SUBJECT: BRES2407-0016
BUILDING RESIDENTIAL

Here are the results of all Inspections located at **114 LAHINCH DR:**

114 Lahinch Drive  
Fugway

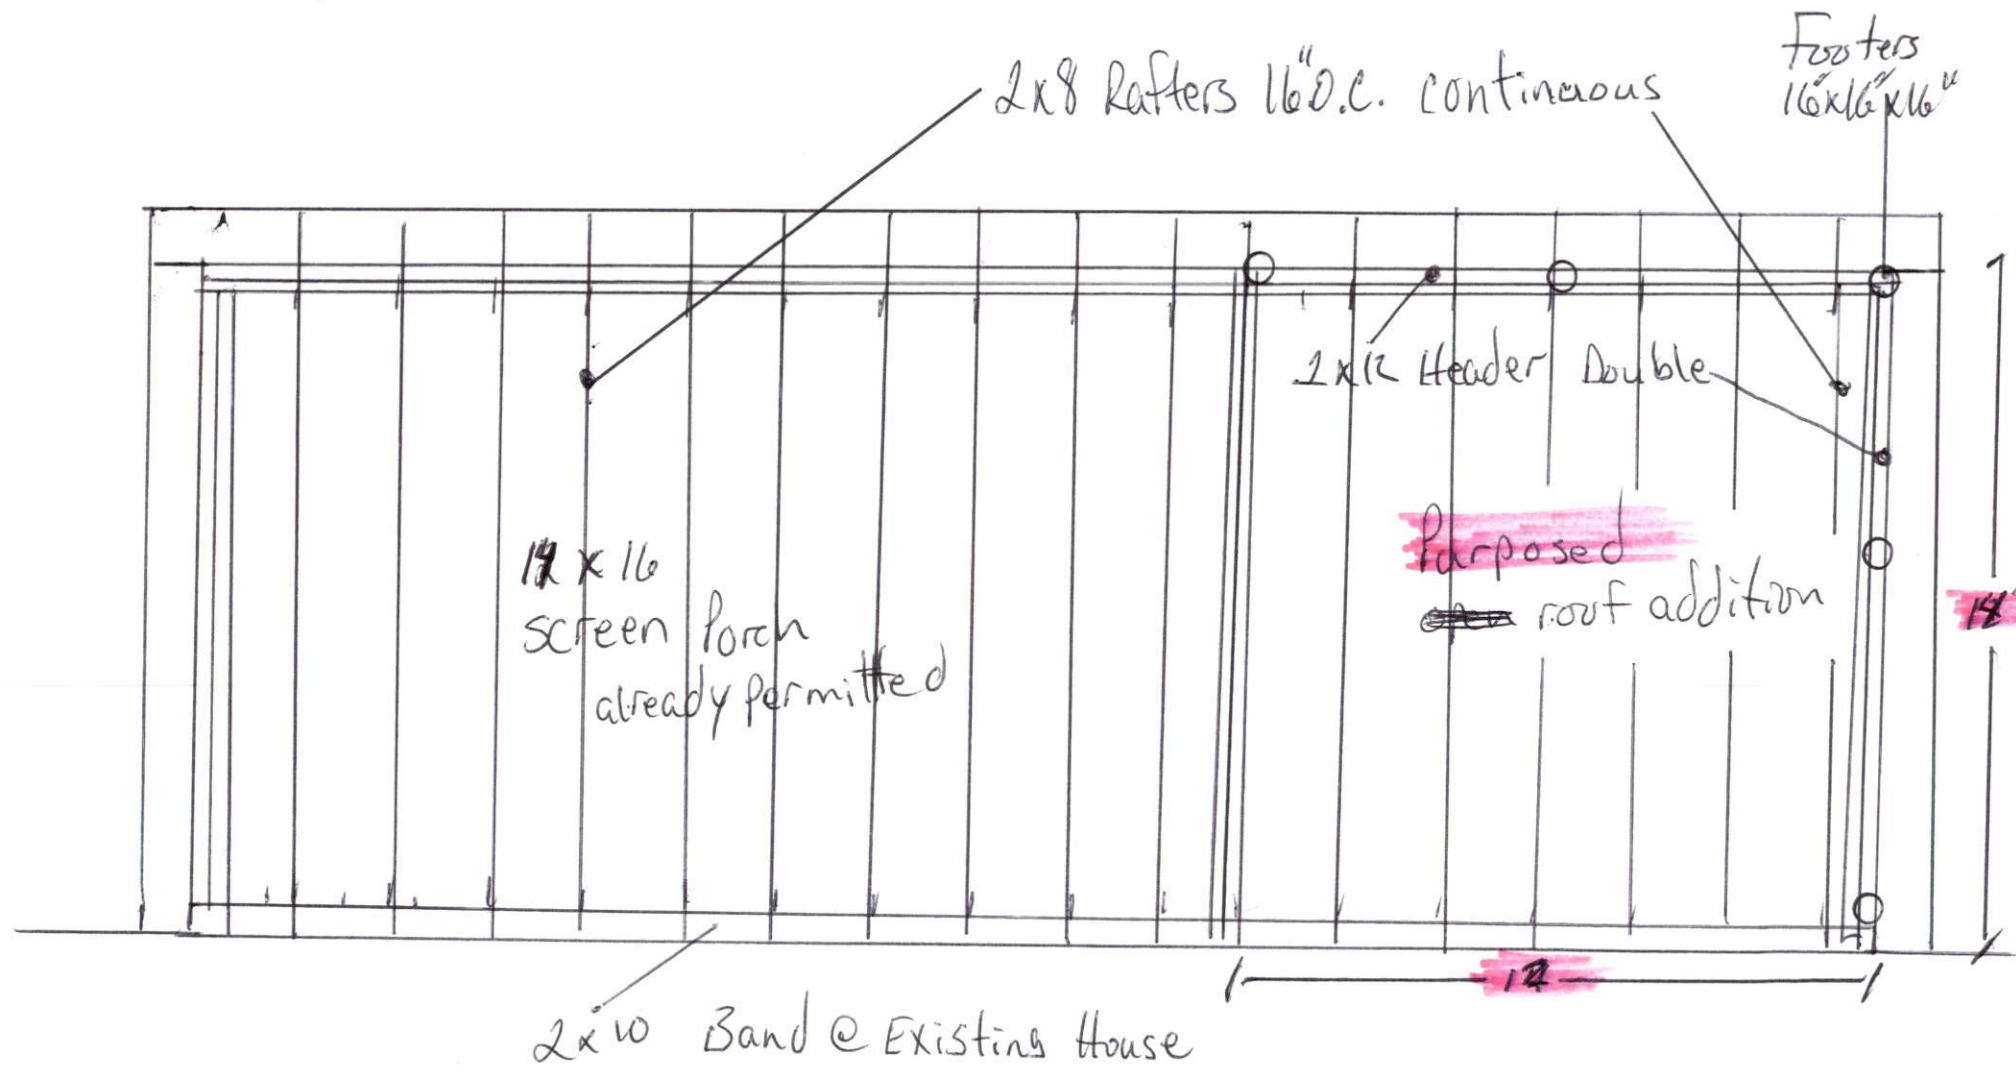
Inspection Type: ROUGH IN
Scheduled Date/Time: 10/9/2024
Completed Date/Time: 10/9/2024
Inspector: Deen Taylor
Result: DISAPPROVED
Remarks:
Notes: Plans call for 16 x 16 footers under posts, none there, footing inspection never scheduled or approved. Mechanically fasten posts to bands under rafters.
